**From:** Holly Duncan  
**Sent:** Monday, April 16, 2012 3:02 PM  
**To:** Jeff Watson  
**Subject:** RE: BL-12-00005 Howard

**From:** Jeff Watson  
**Sent:** Friday, April 13, 2012 3:21 PM  
**To:** Christina Wollman; Brenda Larsen; Jan Ollivier; Holly Duncan  
**Subject:** BL-12-00005 Howard

CRUSE & ASSOCIATES
PROFESSIONAL LAND SURVEYORS
217 East Fourth Street P.O. Box 959
Ellensburg, WA 98926 (509) 962-8242
HOWARD PROPERTY

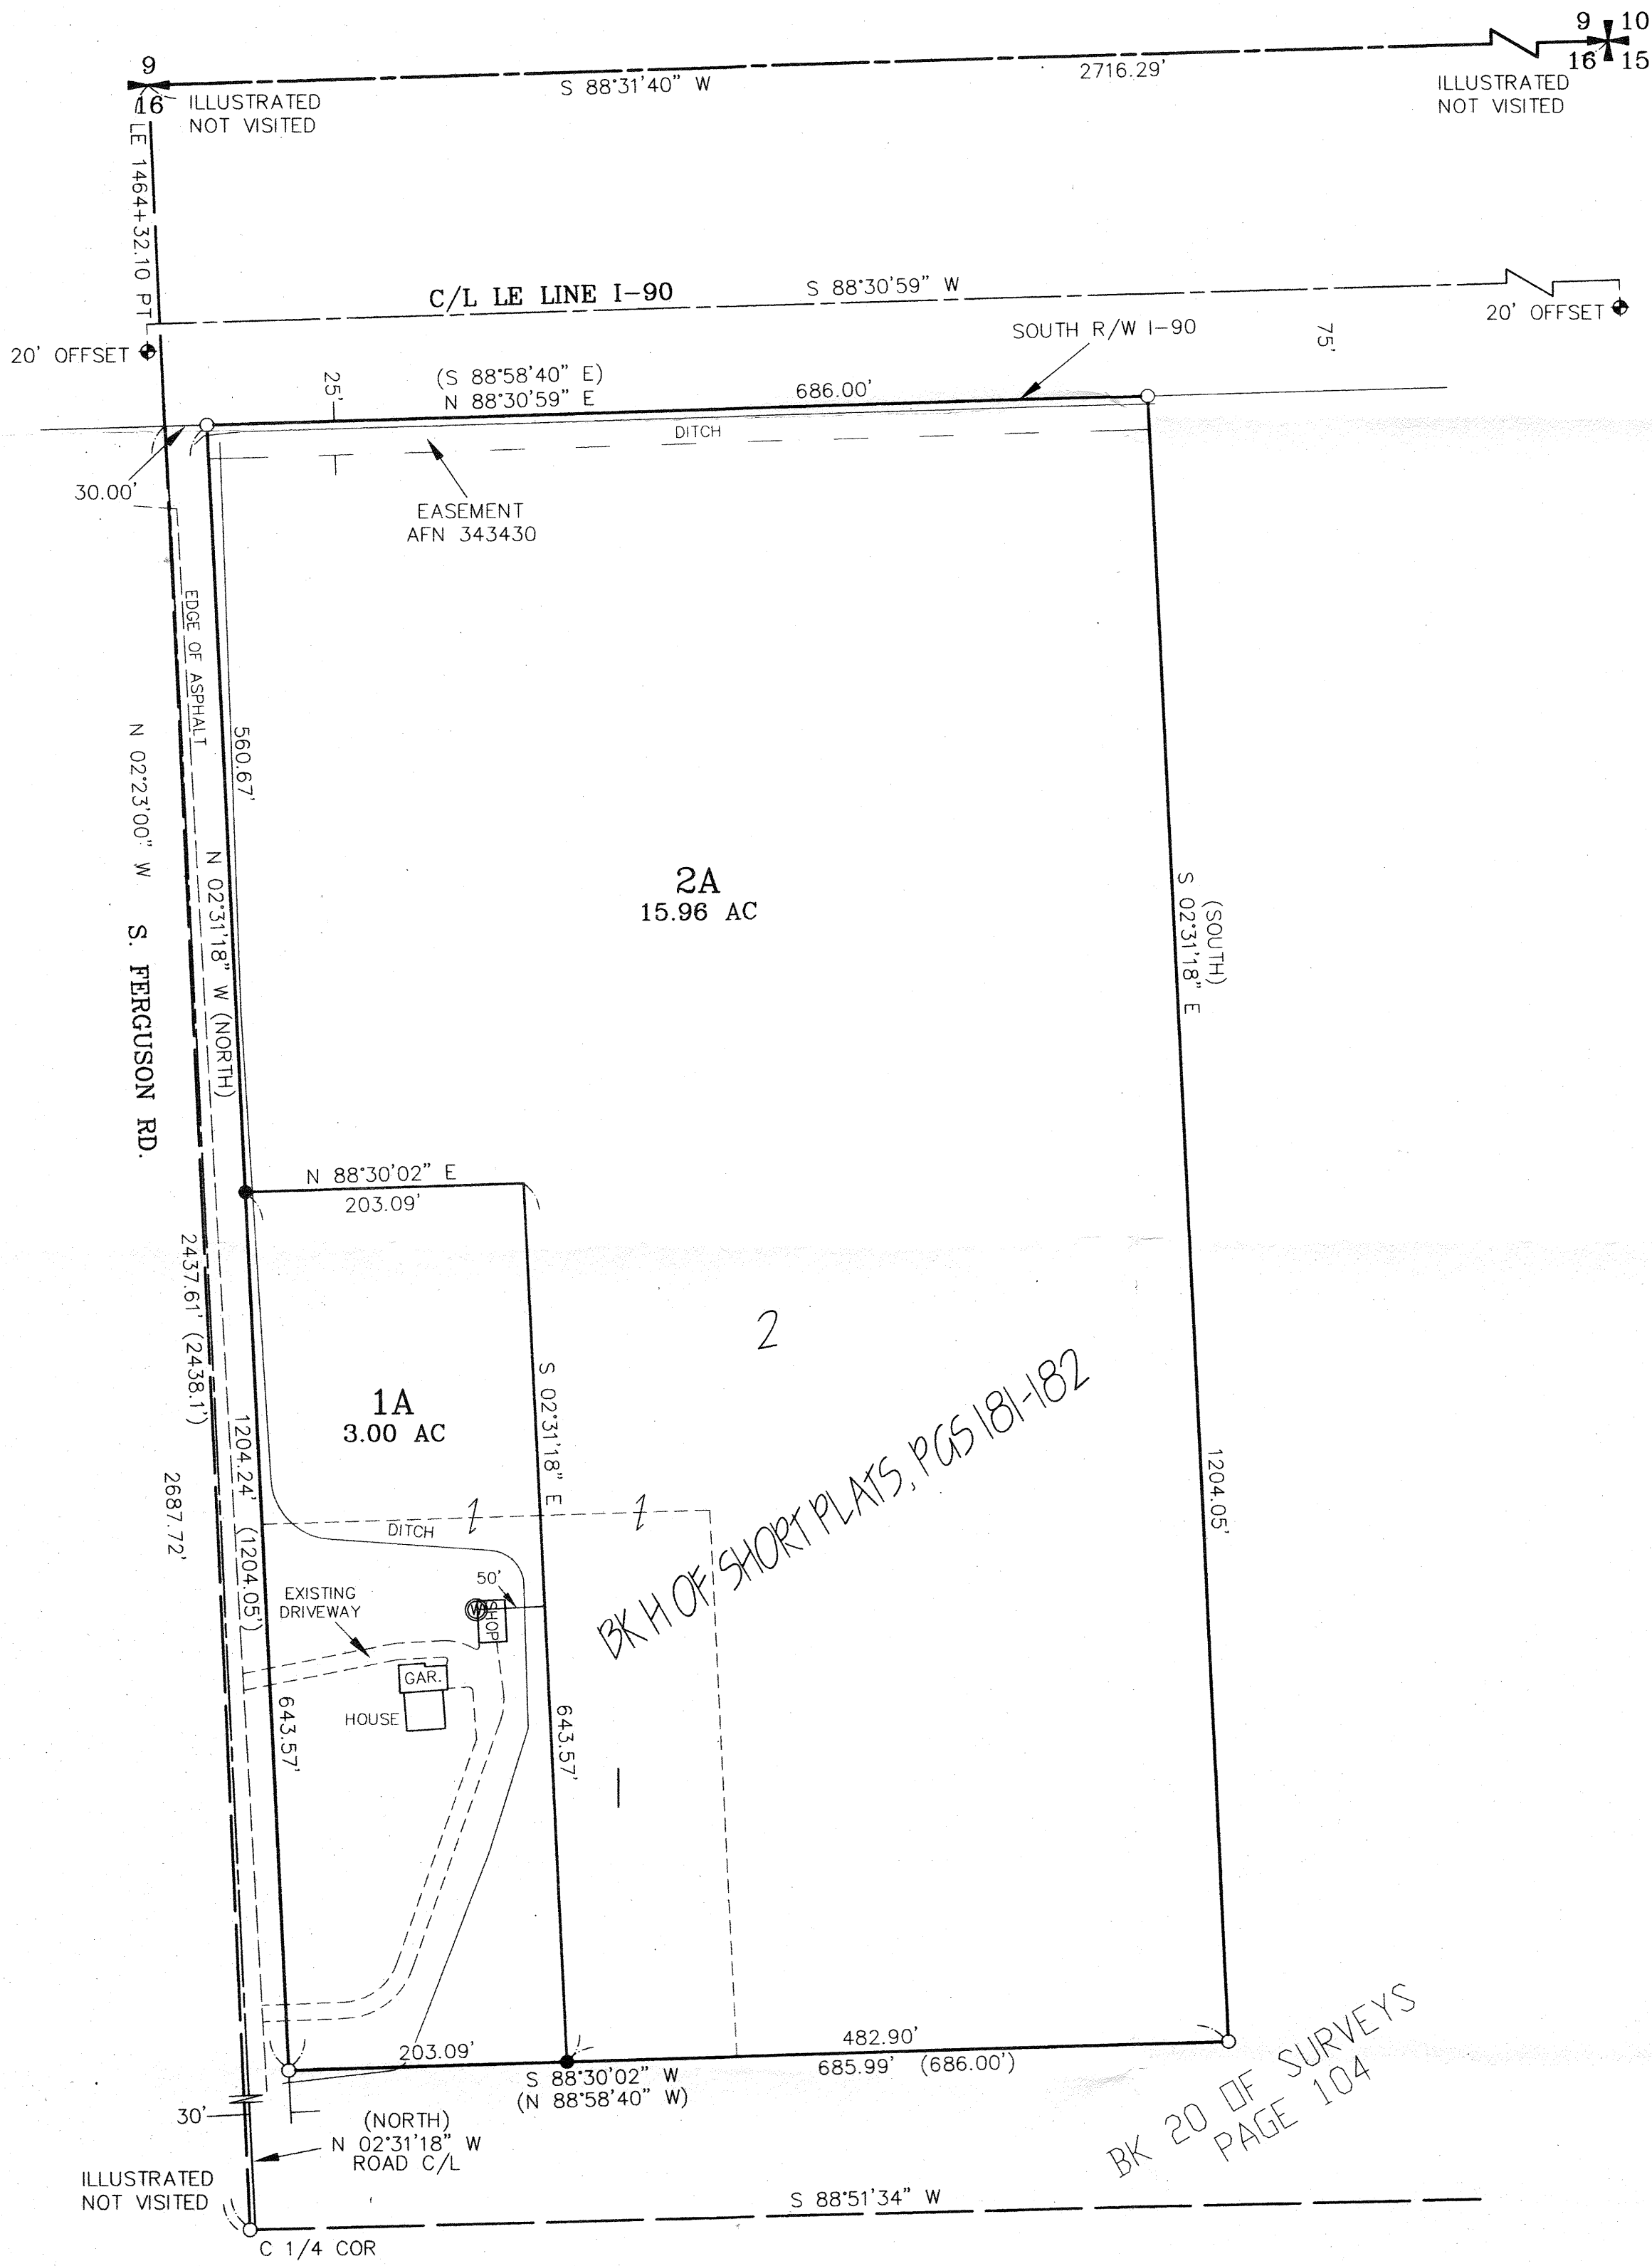
The proposed line must be at least 50 feet from the well and 5 feet from any portion of the drainfield. It is difficult to tell where the well is with the information given.
